Planning Application No: 3/2025/0692

Proposal: Proposed single storey front entrance extension, alterations to existing conservatory and formation of new parking area.

Location: Page House Dilworth Bottoms Ribchester PR3 3ZB

Tahira Akhtar BA (Hons)
Technician
Highway Development Control
Highways & Transport
Lancashire County Council

PROPOSED SITE PLAN
1 : 200

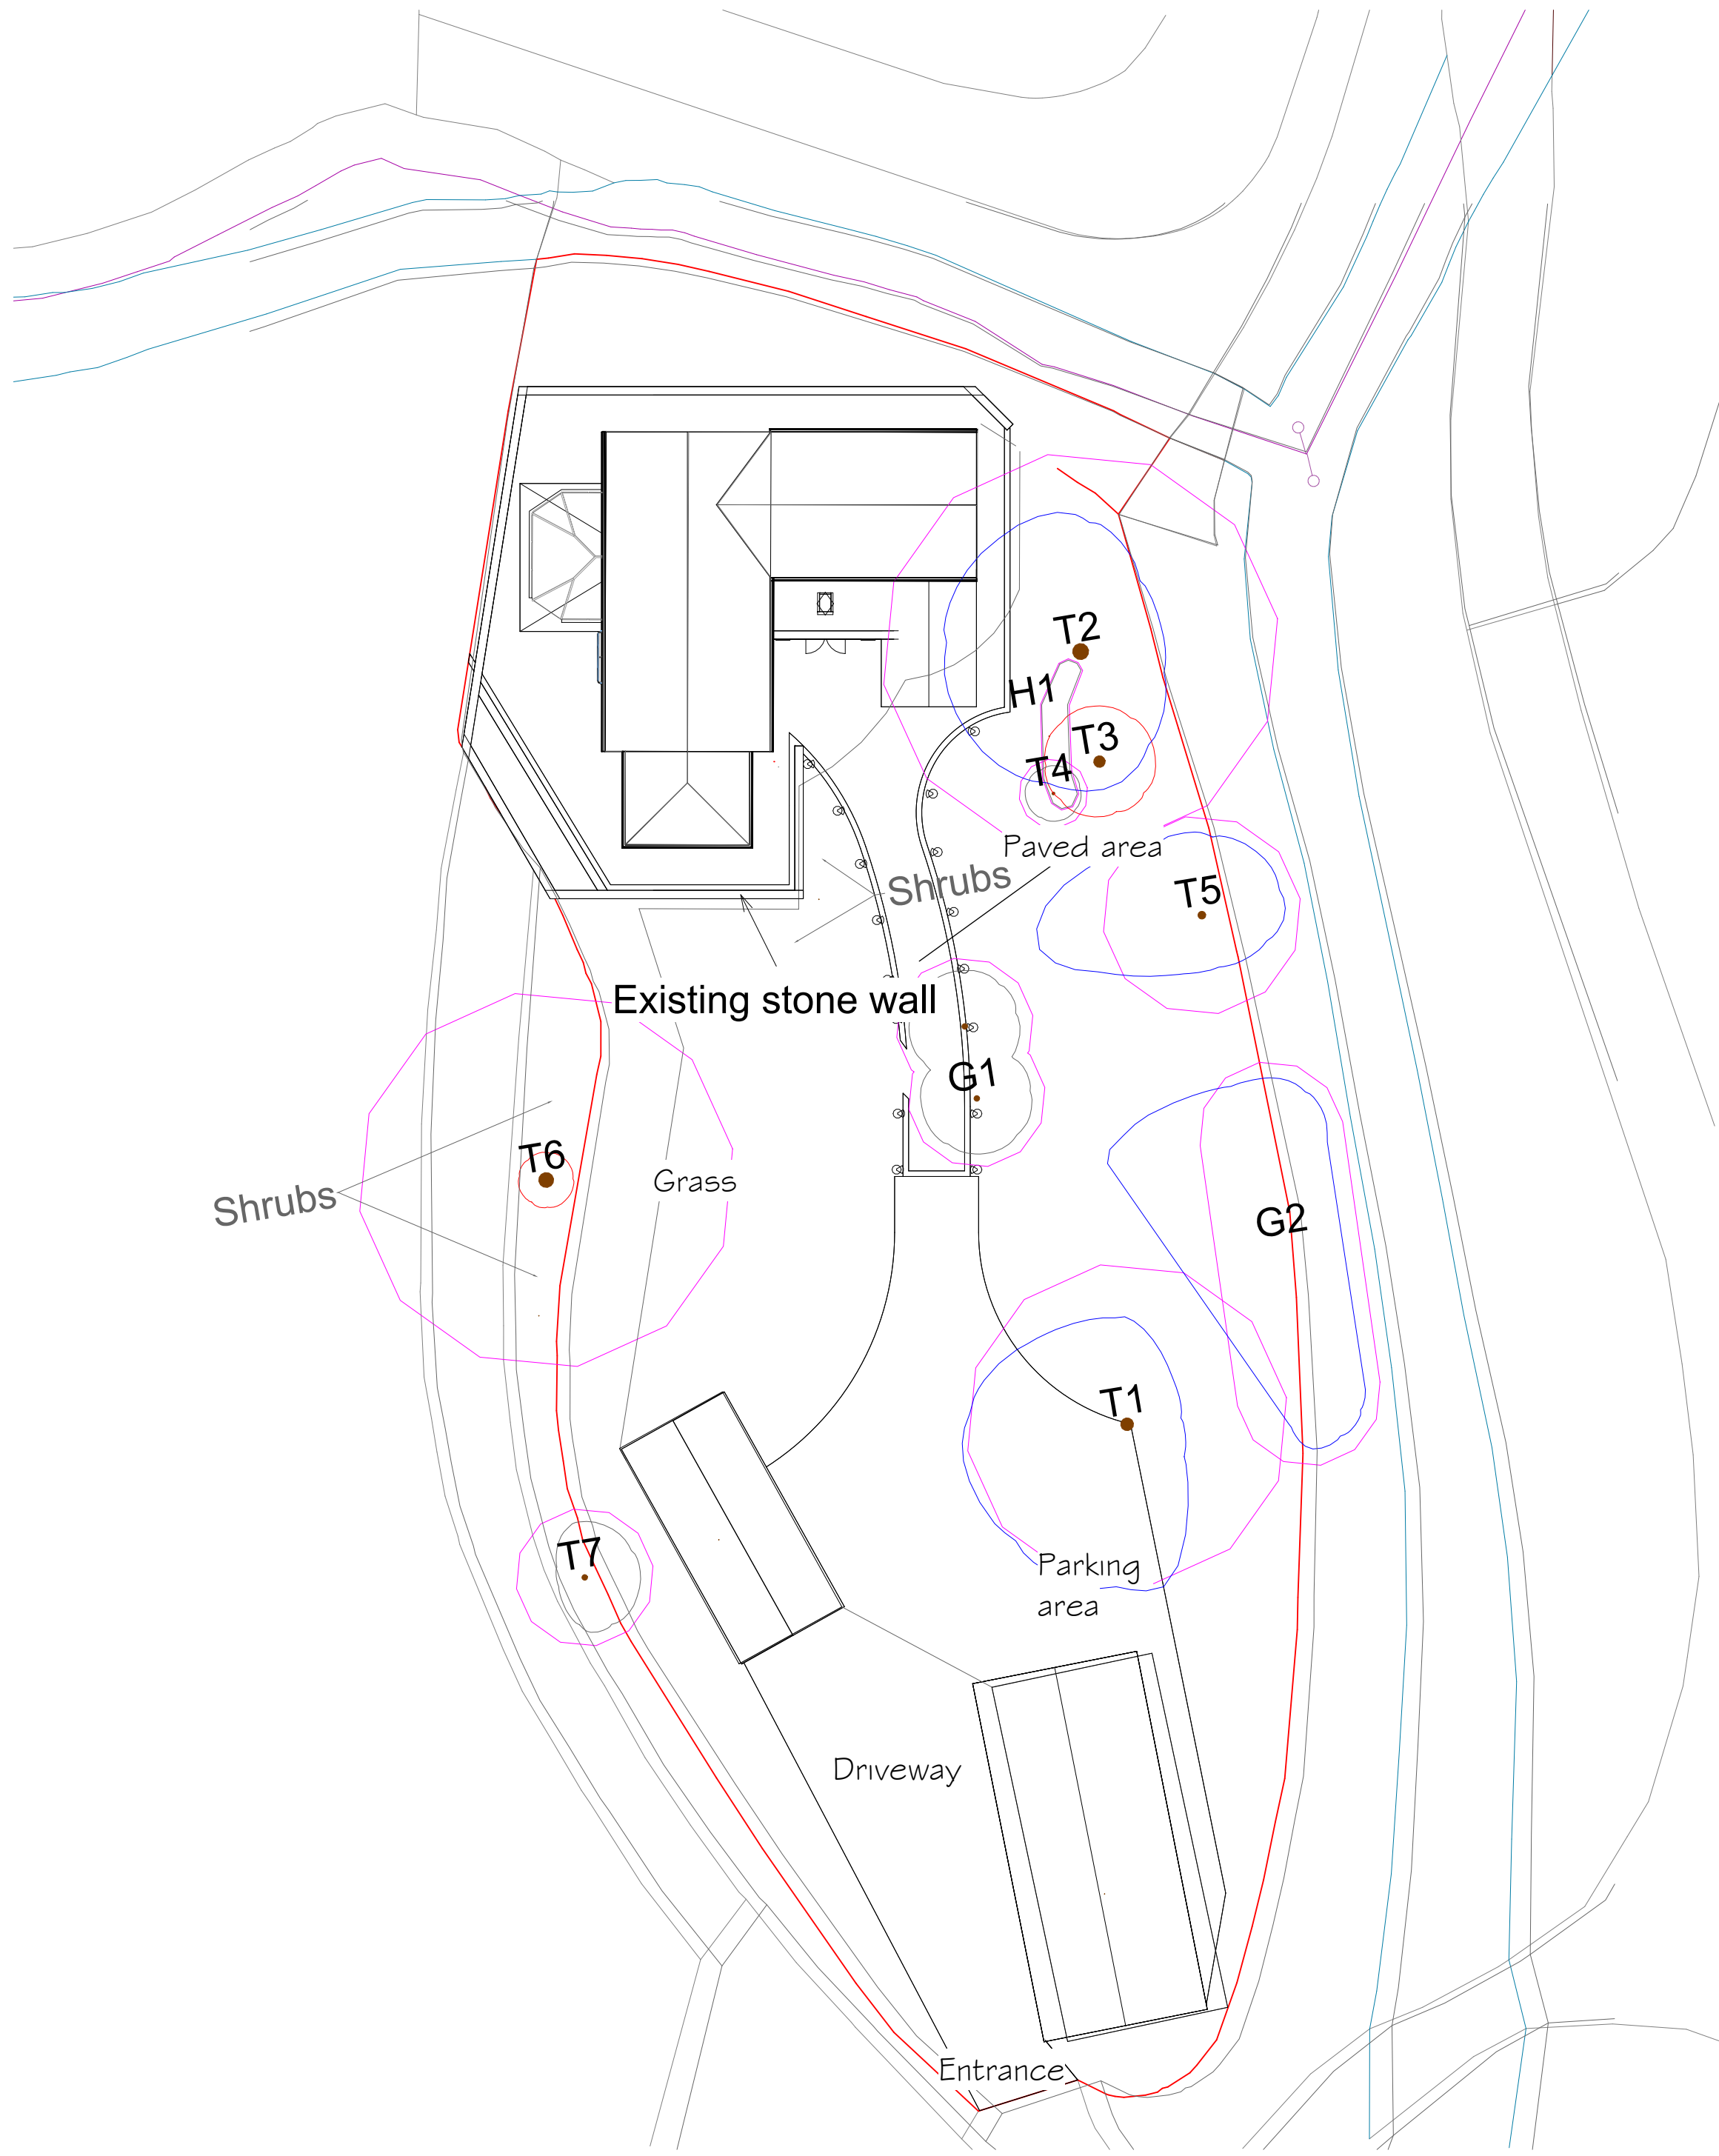
- The parking areas must be constructed of a bound porous material and created before first occupation up until the lifetime of the dwelling existing in its proposed state. Reason: To ensure that satisfactory parking is provided before the dwelling hereby permitted becomes operative.
